Longfield Solar Farm

Statement of Common Ground – Essex County Council, Braintree District Council and Chelmsford City Council (the Host Authorities)

PINS Reference: EN010118

Document Reference: EN010118/EX/8.4(E)

LEGEND	
	EXISTING CARRIAGEWAY
	HIGHWAY BOUNDARY
	INDICATIVE CARRIAGEWAY WIDENING

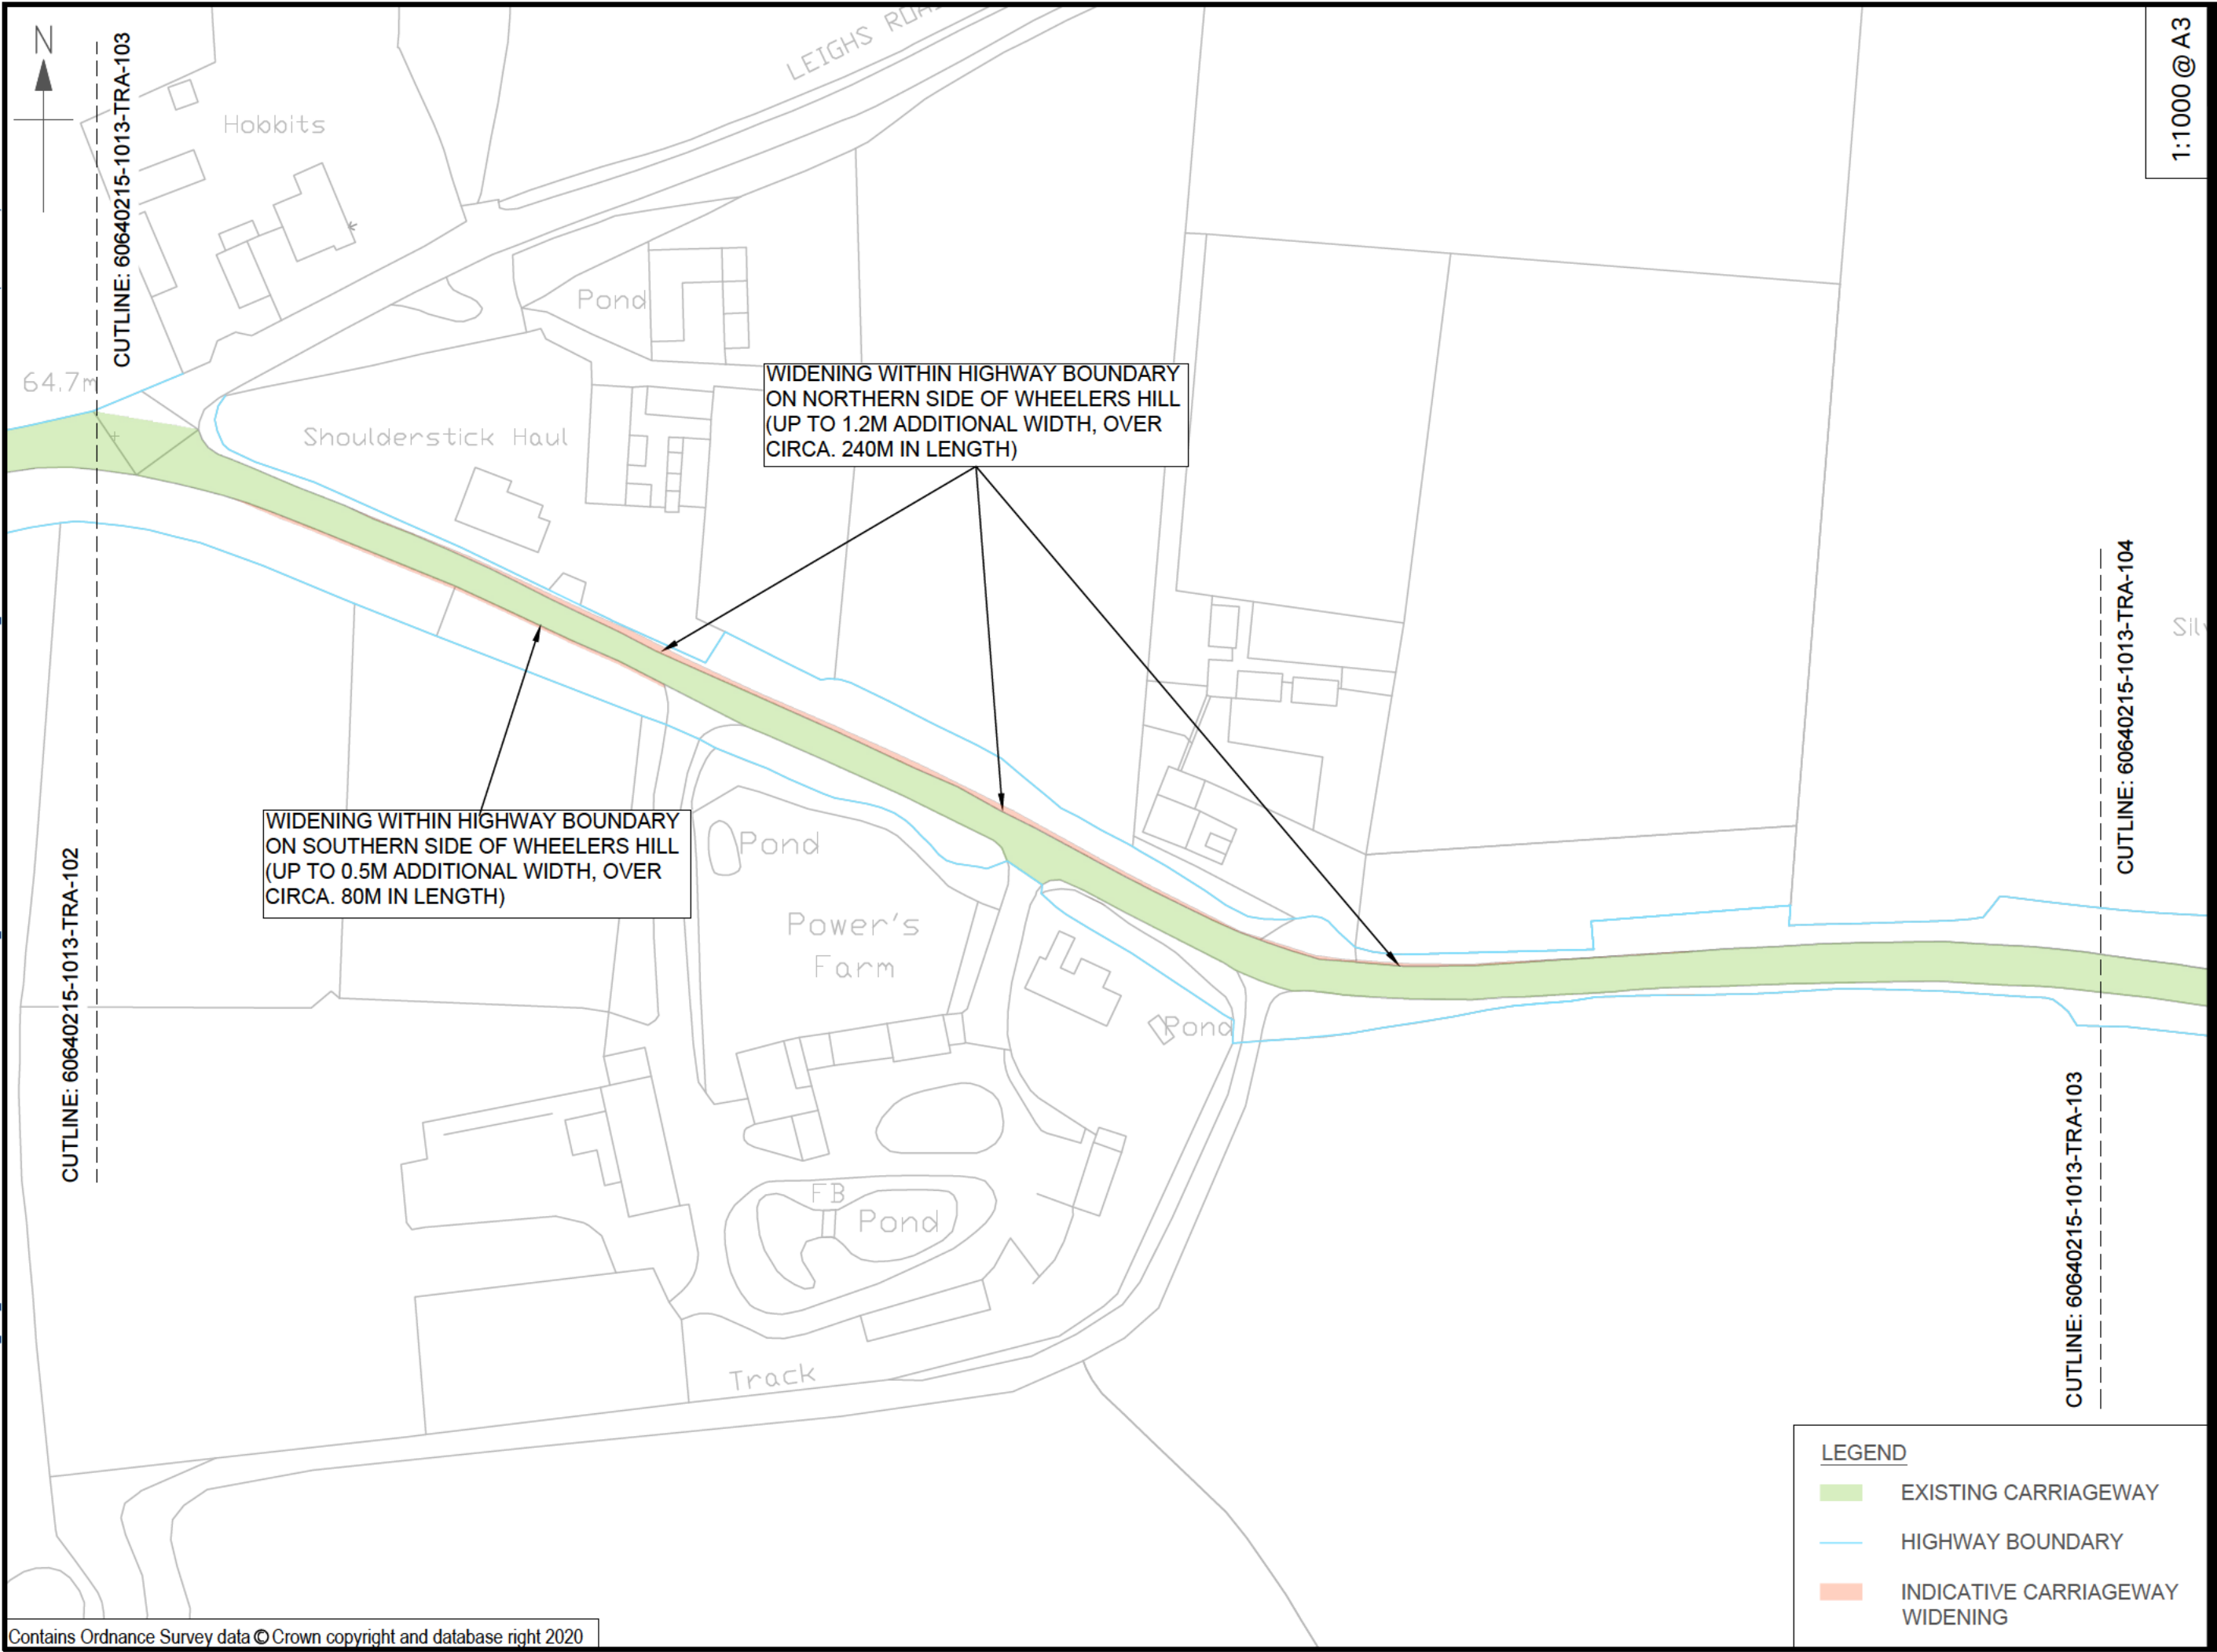
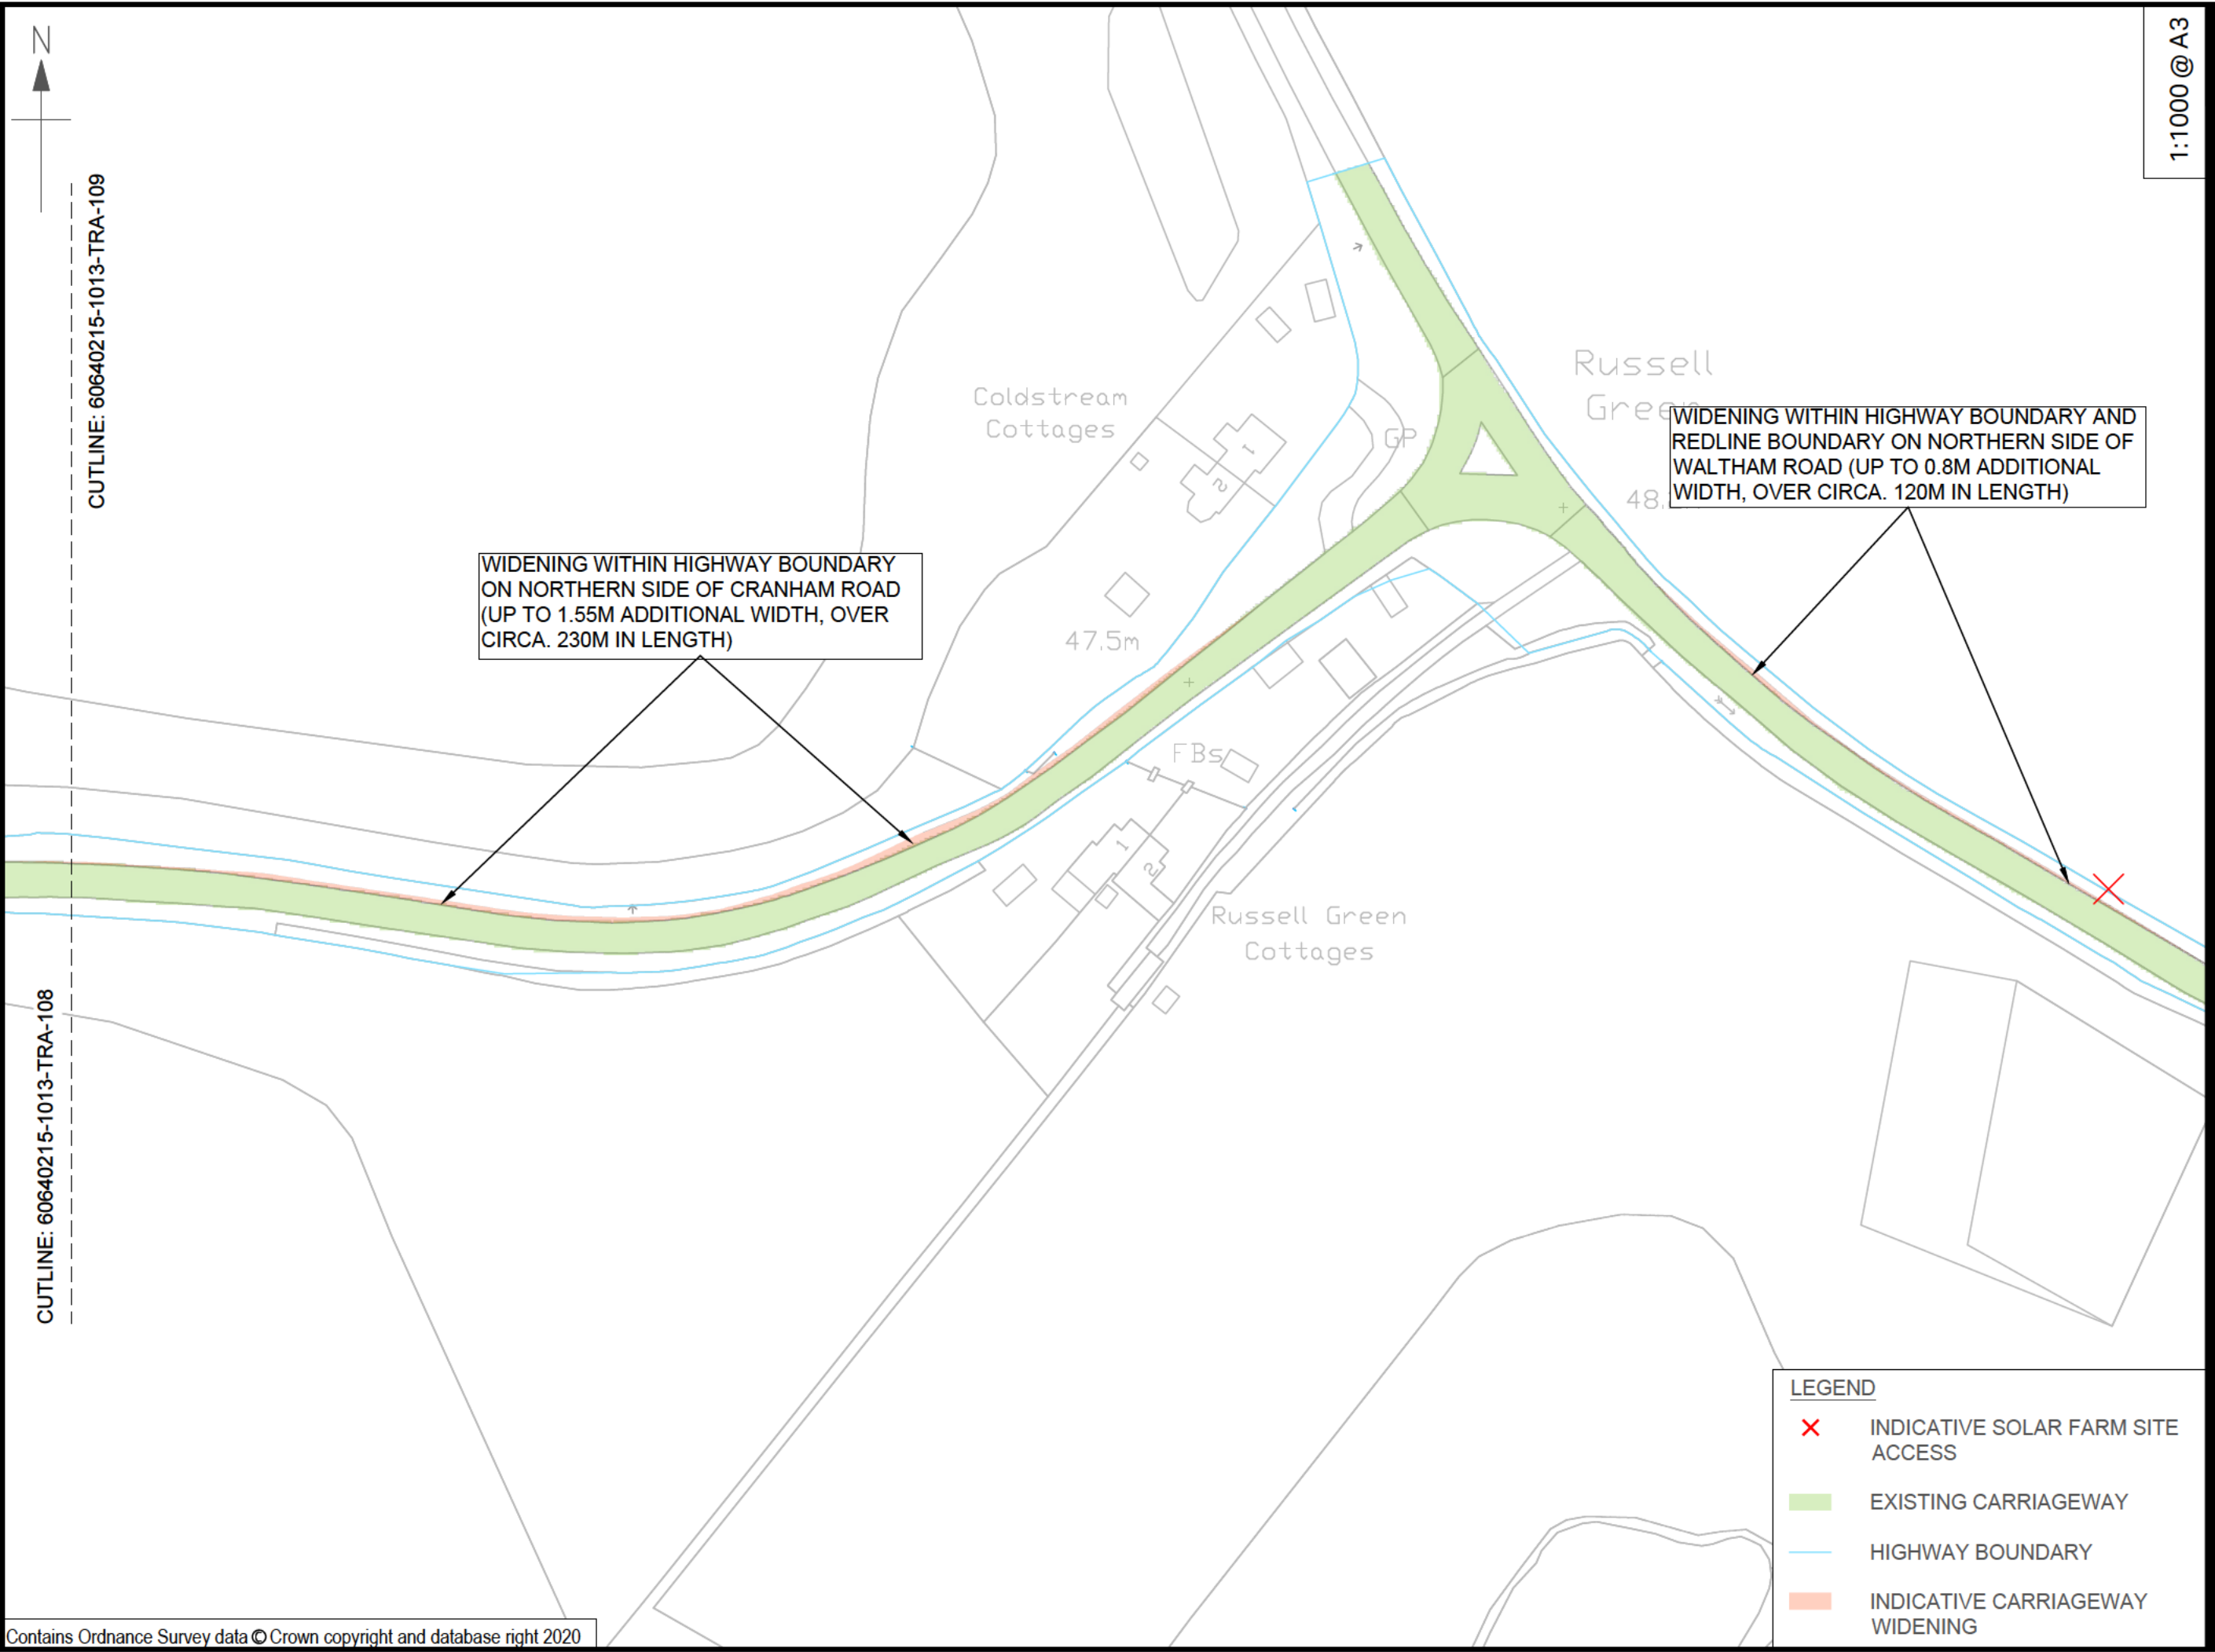
Ref	Sub-topic	BDC's Position	CCC's Position	ECC's Position	Applicant's Response	Status
		<ul style="list-style-type: none"> Proposed carriageway widening on Wheelers Hill, Cranham Road and Waltham Road. Noakes Farm crossing point Locations where permissive routes join or cross existing highway. 			<p>with ECC Highways for review on 12th July 2022. Following this, the only outstanding action was to undertake a RRRAP assessment to determine whether safety fencing/ barriers are required on Waltham Road as a result of Longfield Solar Farm which can be accommodated within the highway or land within the control of the Applicant. The RRRAP assessment was carried out in October 2022 and the Designer's Response was updated to reflect the findings/ recommendations. The updated Designer's Response and RRRAP was shared with ECC Highways on 1st November 2022.</p> <p>The remaining points picked up with the Stage 1 RSA have been addressed as part of the Designer's Response and as such no further actions are considered to be required following the completion of</p>

Ref	Sub-topic	BDC's Position	CCC's Position	ECC's Position	Applicant's Response	Status
TRA-05B	Condition Survey	ECC: ECC considers that despite the widening to 6 metres, where possible there remains the possibility that additional traffic could impact on the condition of the highway asset and verges adjacent to the highway. The Construction Traffic Management Plan should include reference to before and after studies for any vulnerable sections of the highway asset being required together with a programme for reinstatement of any defects both during and after the construction period.			A condition survey will be carried out on Wheelers Hill, Cranham Road and Waltham Road (125m section between Cranham Road and the proposed site access) pre-construction, during construction and post-construction, to identify any defects that arise to highways assets/ verges during the construction phase of the Scheme for re-instatement. This will be secured within the Framework CTMP which has been updated and resubmitted accordingly.	ECC: Agreed following the meeting on 26 th September 2022 and on the basis that the Framework CTMP has been updated.
